Date: 03/22/2022

Permit #: ERES2109-0015

Project Name: Corrine Yonas

Address: 46 Fetch Court

DRAWING BY Jake Lamb	
DATE March 23, 2022	
PROJECT NUMBER 376340	
SHEET NAME ELEC. 3 LINE DIAG.	
PAGE NUMBER PV5	REVISION A

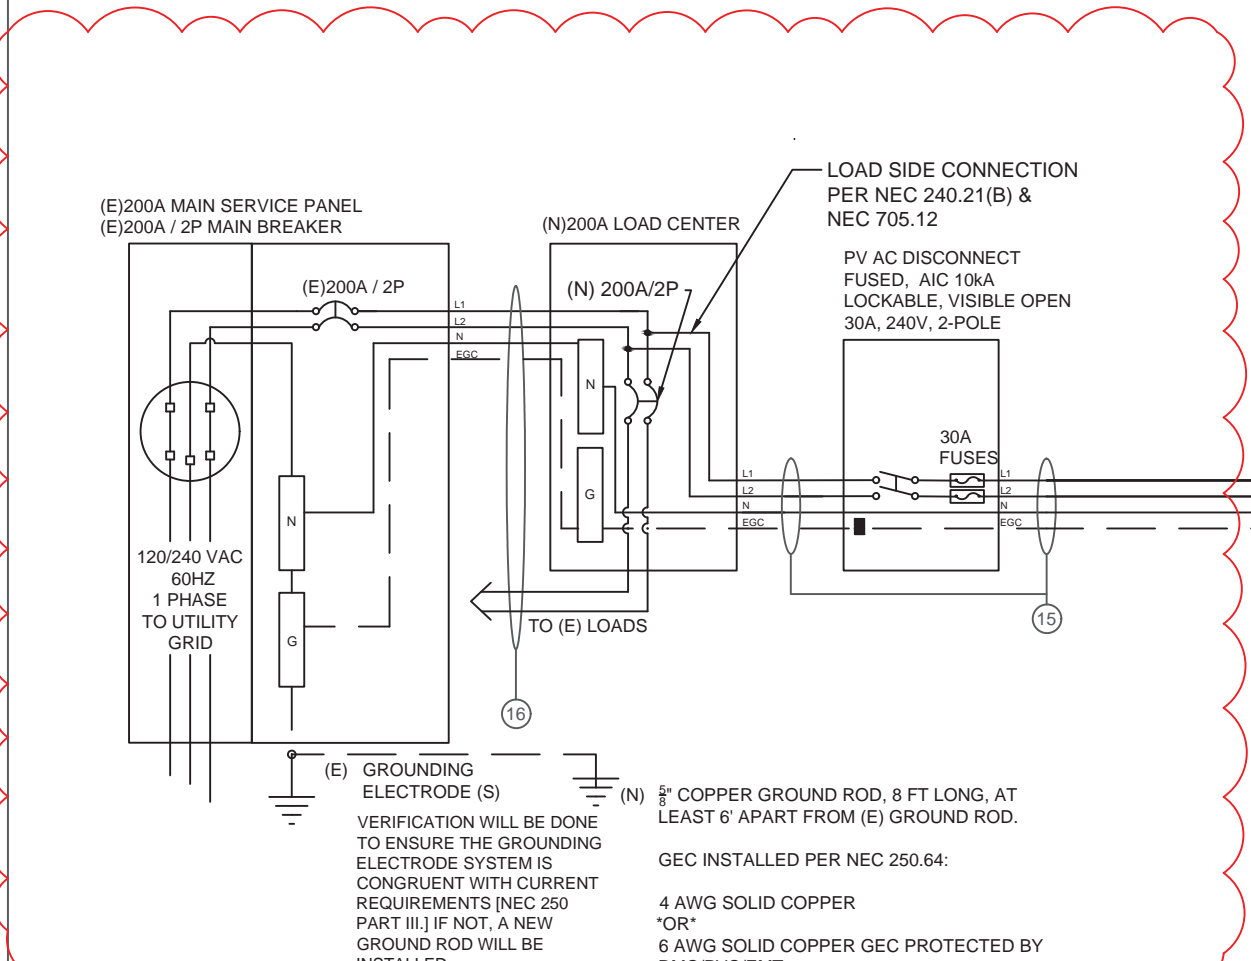
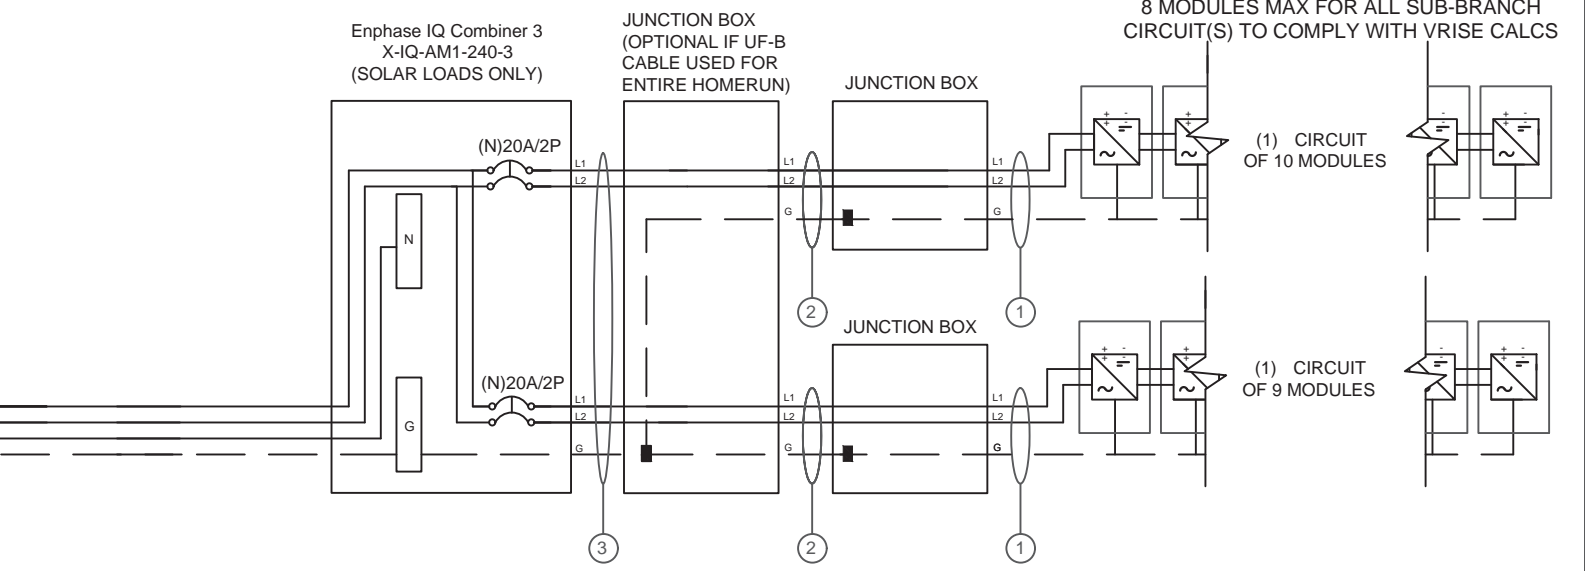
PV5 has been updated to show a redirected main with a load side tap.
